Mr. P. Simmonds
3 Coachhouse Cott.
West Drive
Angmering
DN.16.4TE

With regard to the
application Nr A/12/17 H.H.

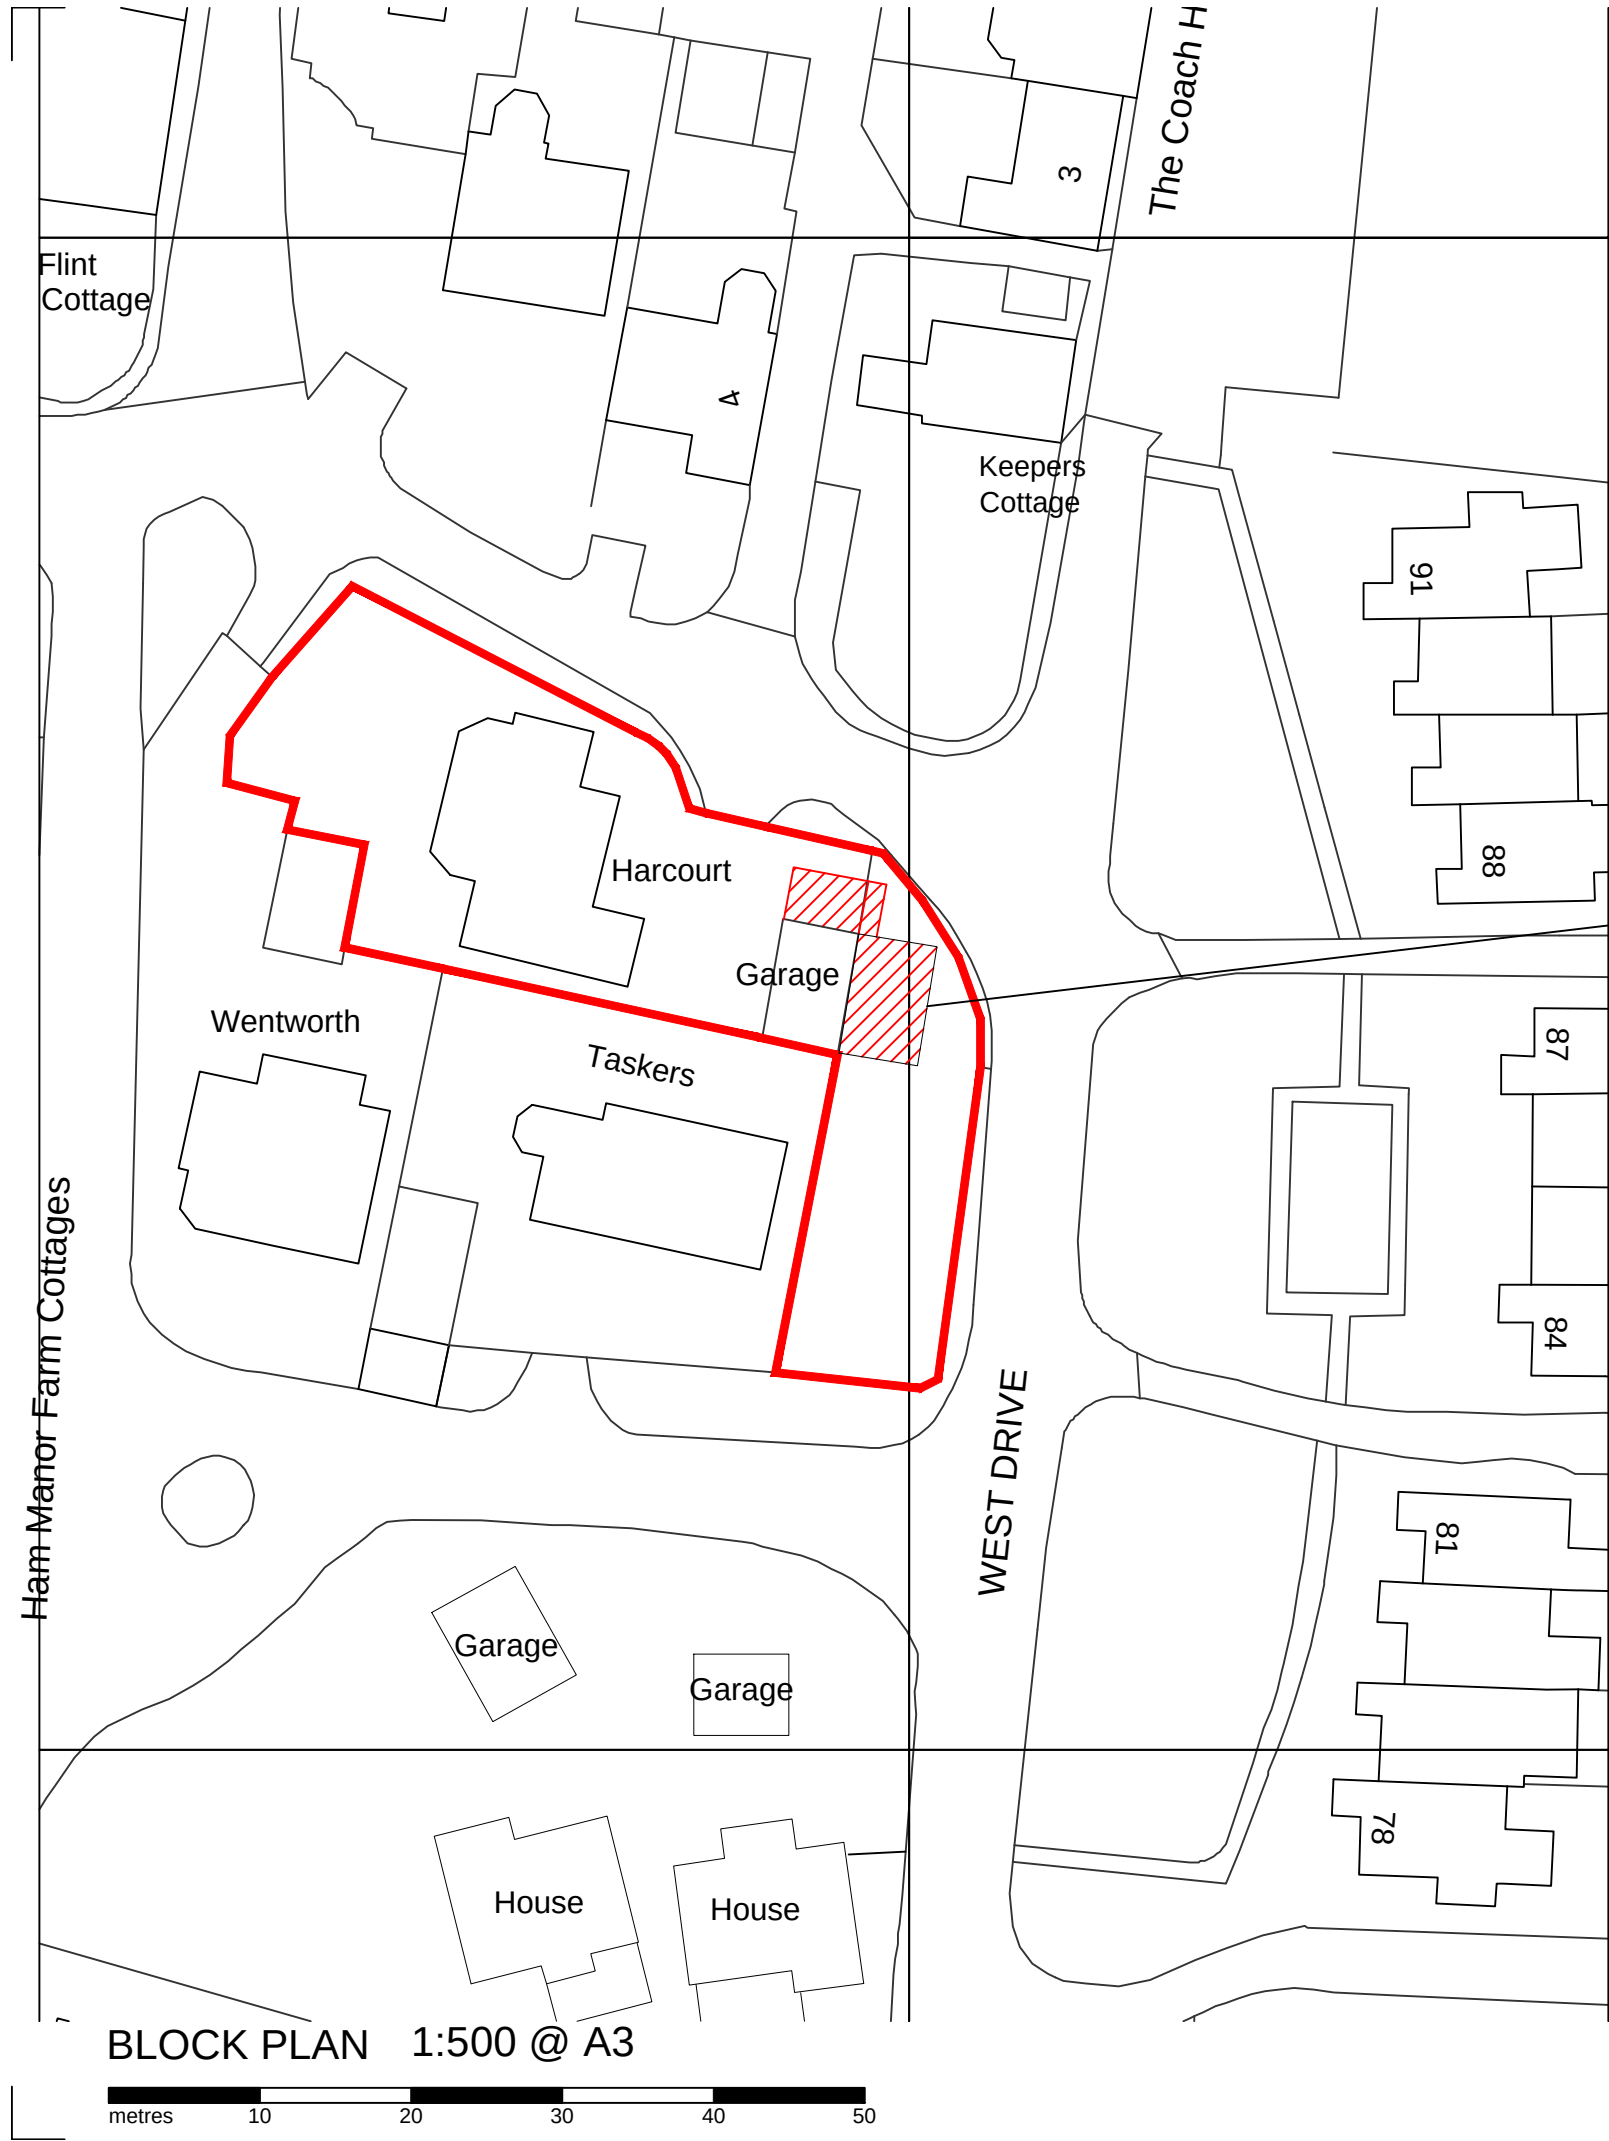
I have no objection to
the plan to build a double
garage, providing the exit &
entrance does not come out
directly onto the West Drive
which I consider dangerous
in view of the narrowness
parked cars & the increase in
traffic proposed.
